Application for Reserved Matters application following Outline Planning Permission AL/39/13 for the demolition of Oakdene and all other structures within the site and the erection of 79 dwellings, public open space, children's play areas, landscaping, drainage measures, sub-station, pumping station and all other associated works.

Land West of Westergate Street & East of Hook Lane Westergate

Thank you for your internet representation made on 7th November 2016 which has been recorded as '**an objection**' with the comments as follows:

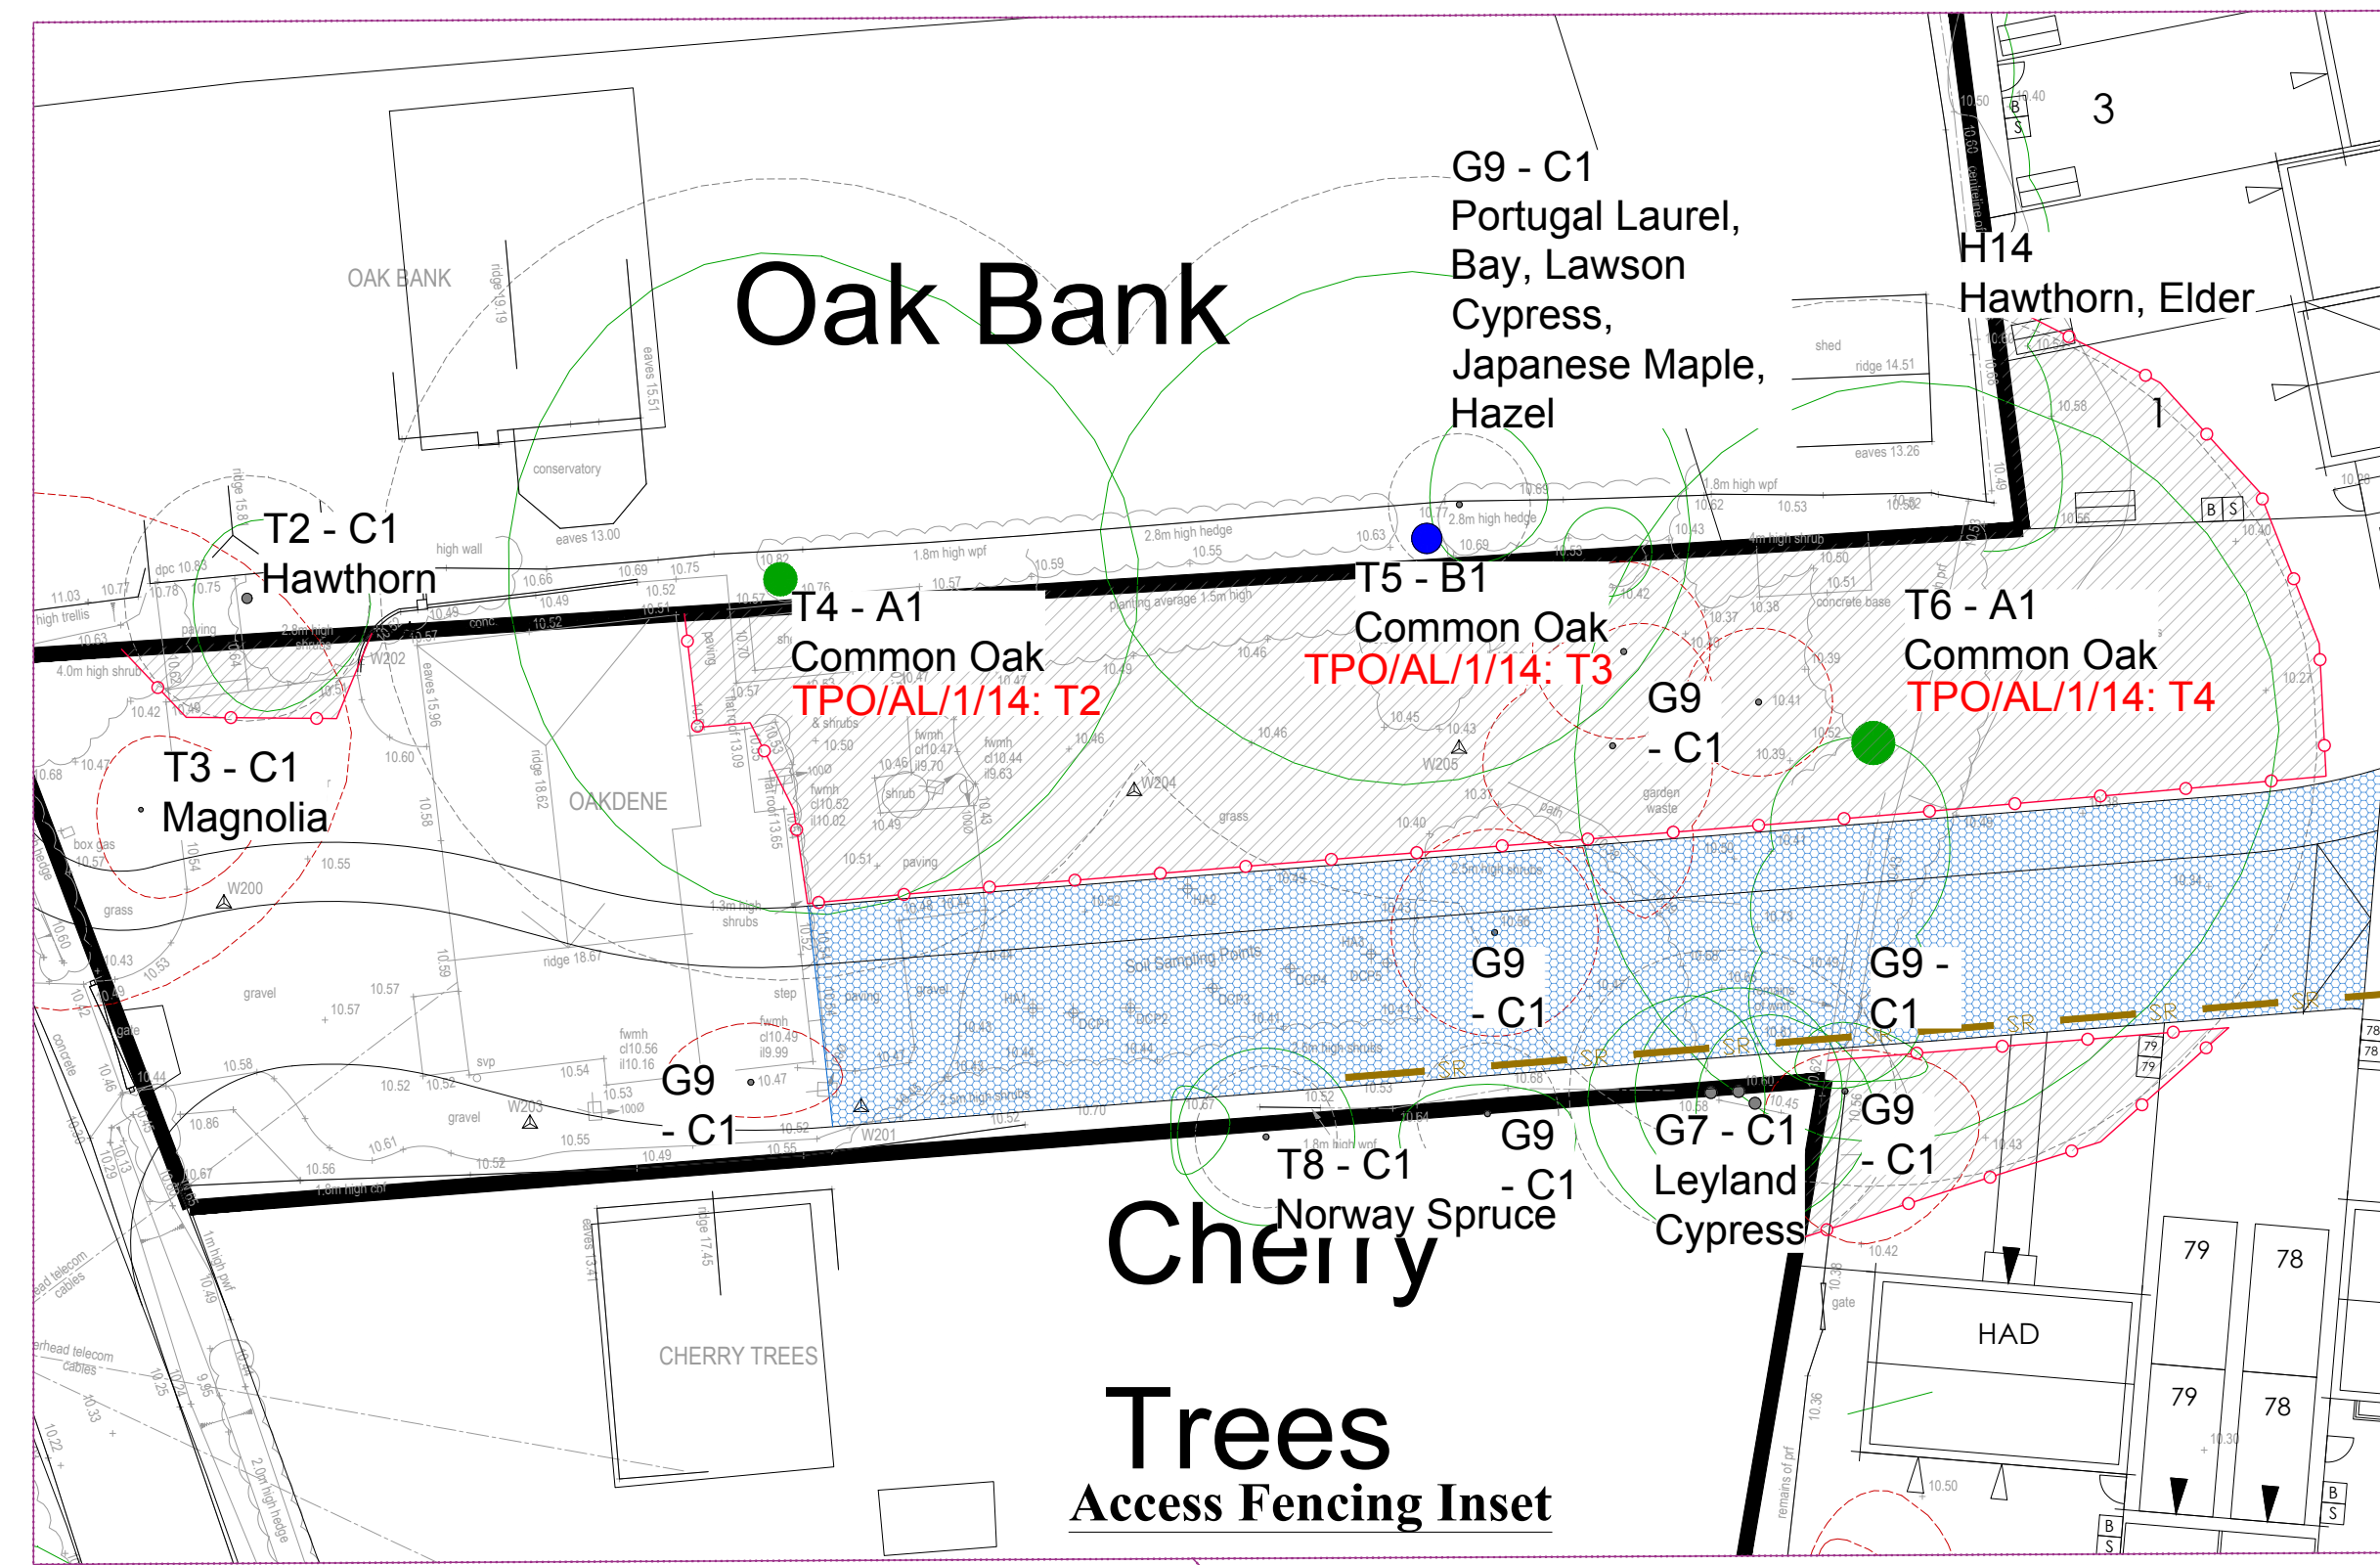
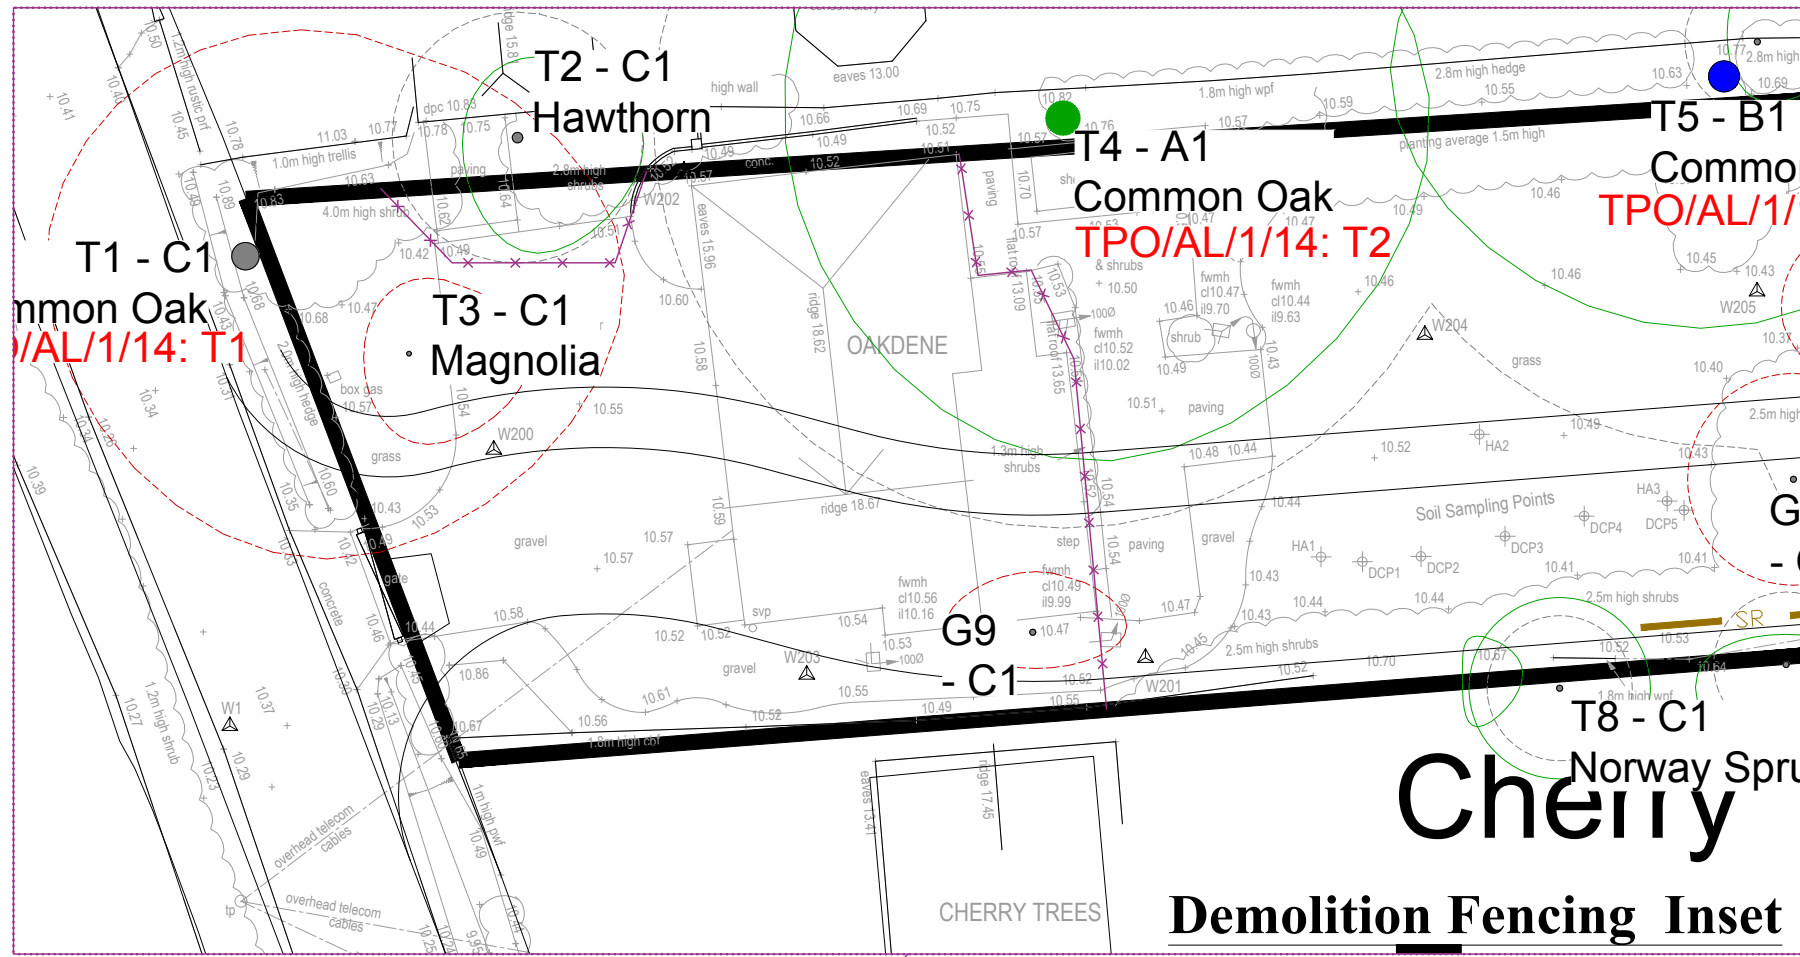
I refer to the Revised Tree Protection Plan:

The mature Eucalyptus tree at the bottom of my garden has still not been recognised on this plan. It is a large tree of approximately 30 years old. The mature Ornamental Hawthorn at East boundary of my property and the mature tree in my front garden close to the boundary are also missed from the report. These trees also need to have their roots protected.
